Project No. 21101

**Re: PA22-024- Marysville 44th PRD – Technical Review 2
7315 / 7417 44th St NE – APN(s) 30053500303700 / 30053500303600**

This letter is provided as response to comments dated November 7 and November 8, 2022. Each item has been carefully reviewed and considered and the following is a summary of how each item was addressed.

DRAWING: **C3**
 SHEET: **3** OF **9**

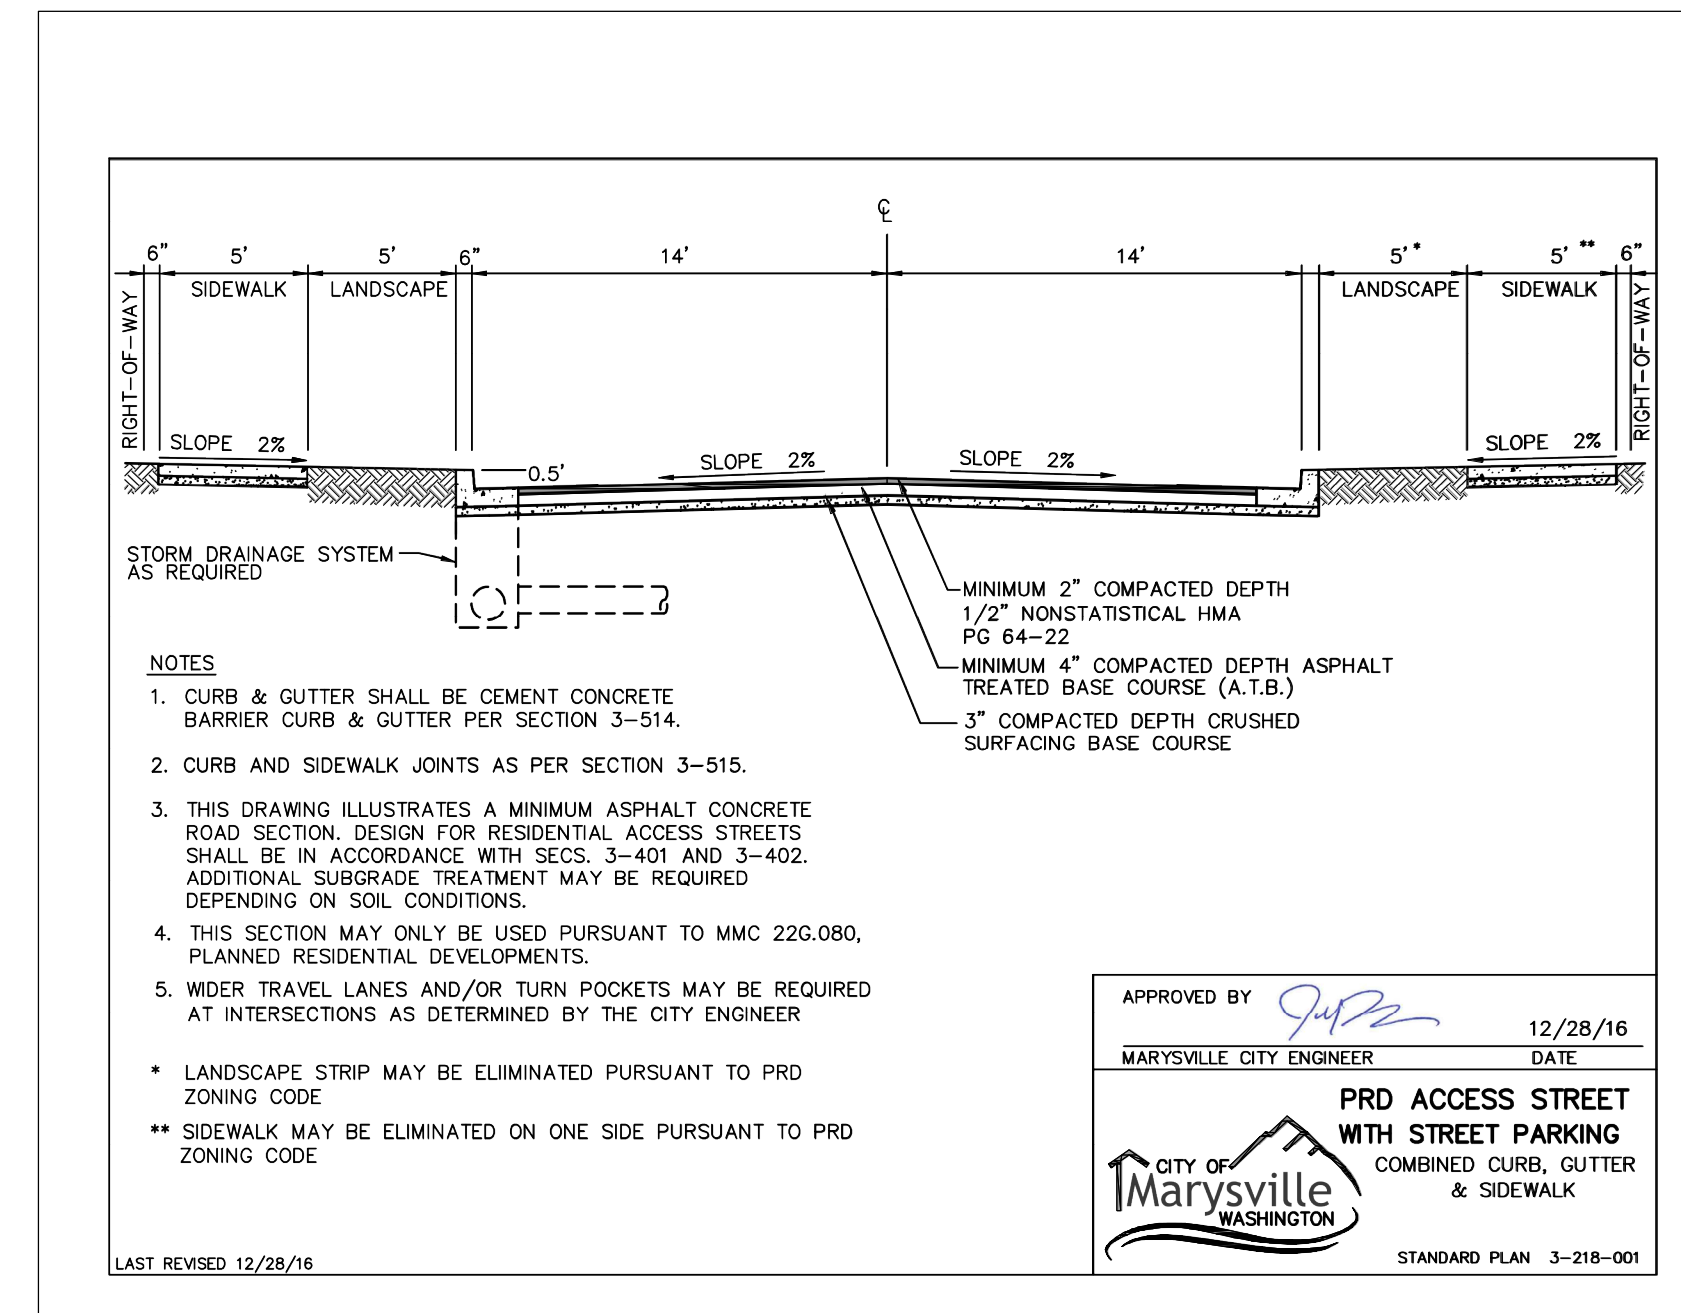
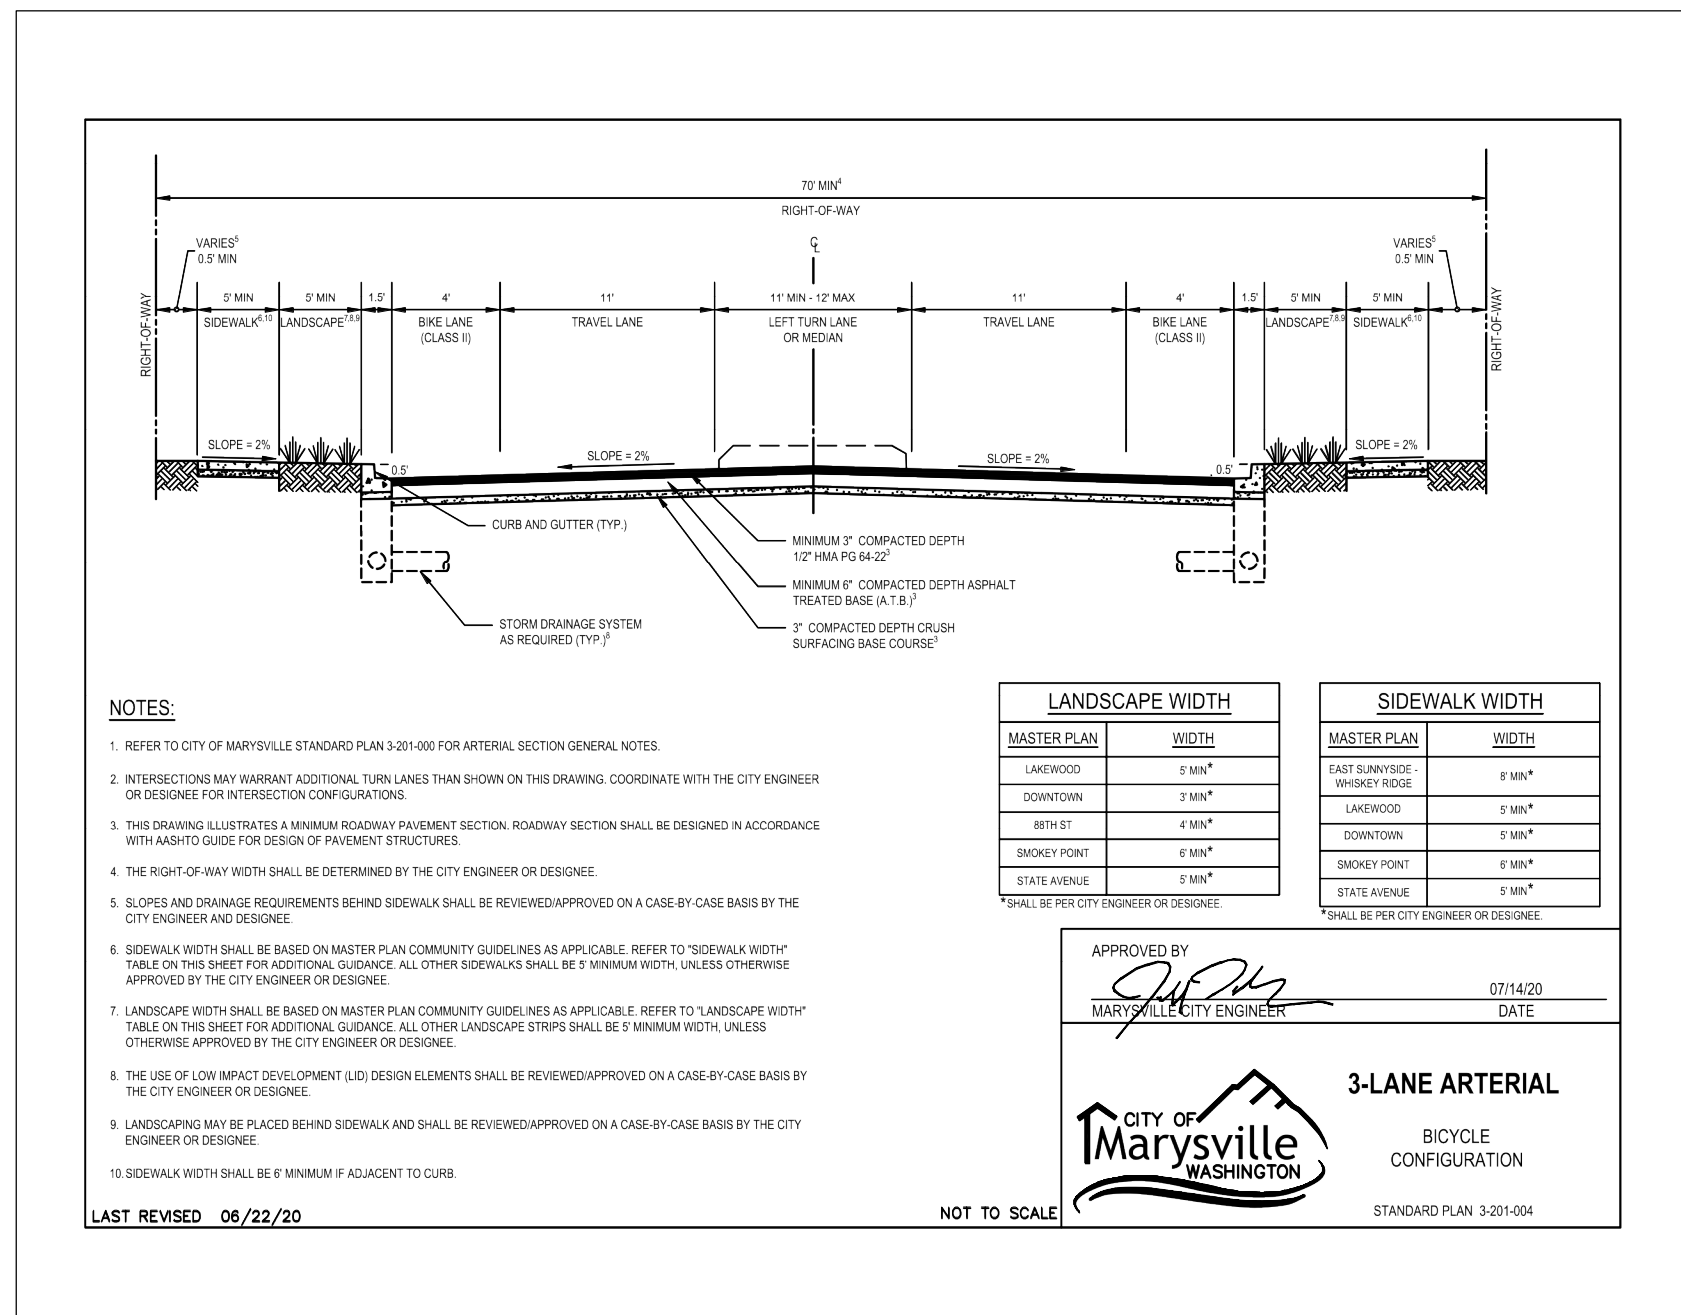
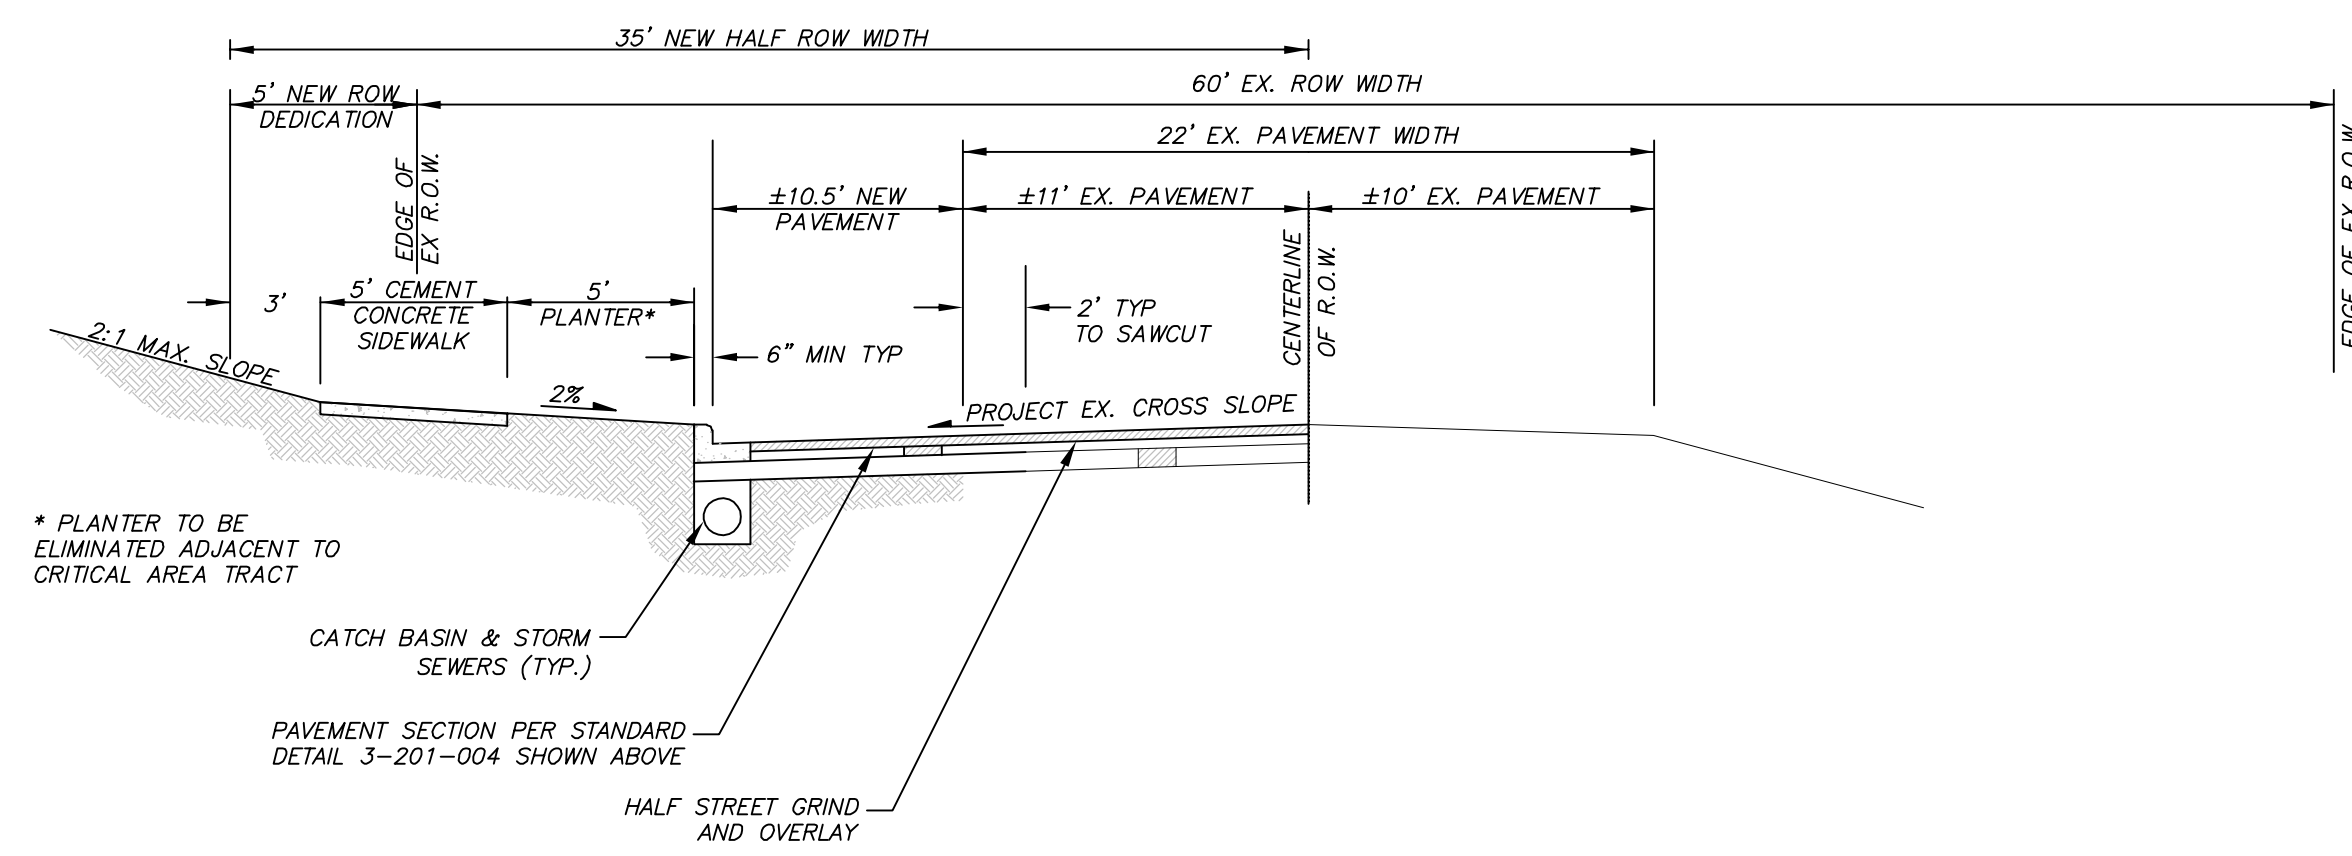
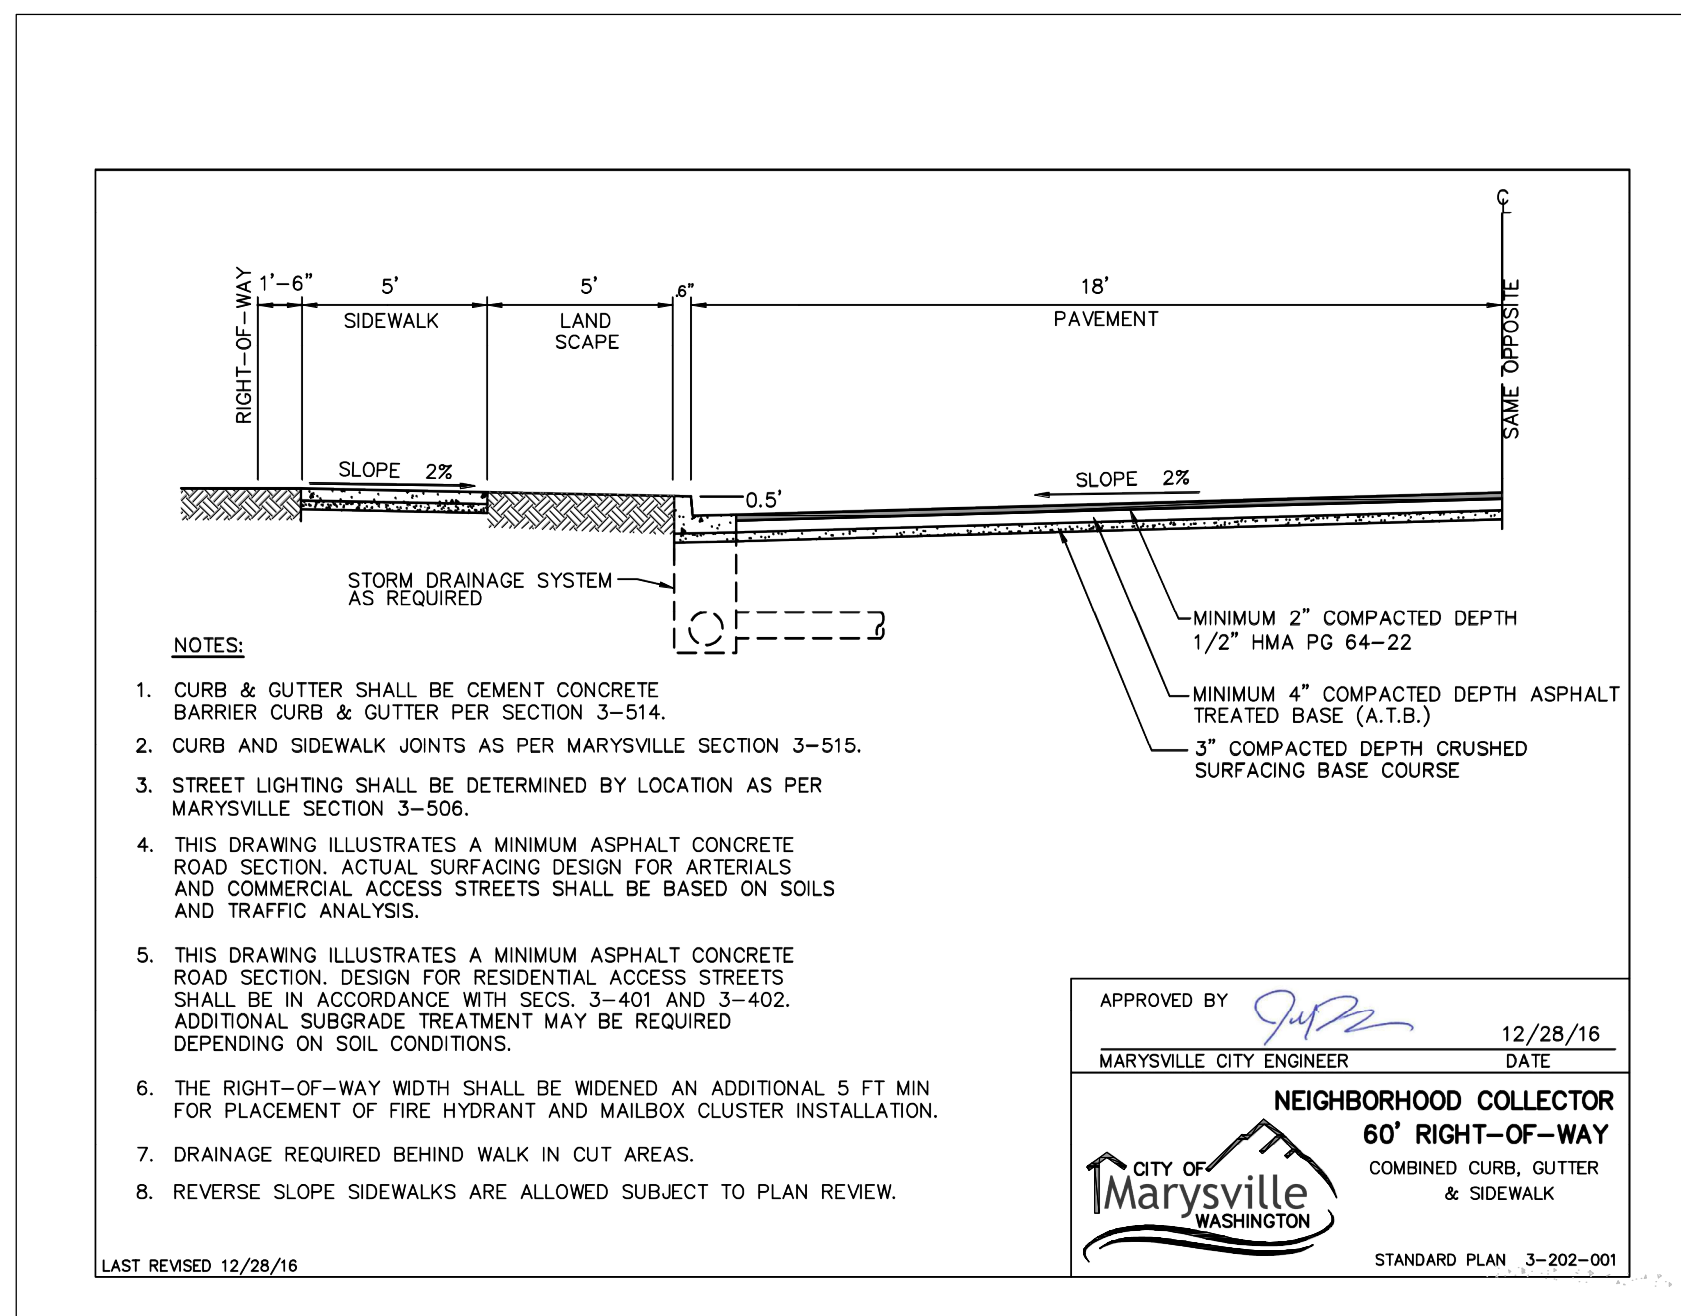
1. 44th ST NE:
 - a. Provide Stationing on 44th ST NE.
 - b. Site specific roadway cross-section *showing existing and proposed* components with dimensions within full ROW should be included upon plans.
Both are provided now.

2. 75th Ave NE:
 - a. Provide Stationing on 75th Ave NE.
 - b. Site specific roadway cross-section showing existing and proposed components with dimensions within full ROW should be included upon plans.
Both are provided now.
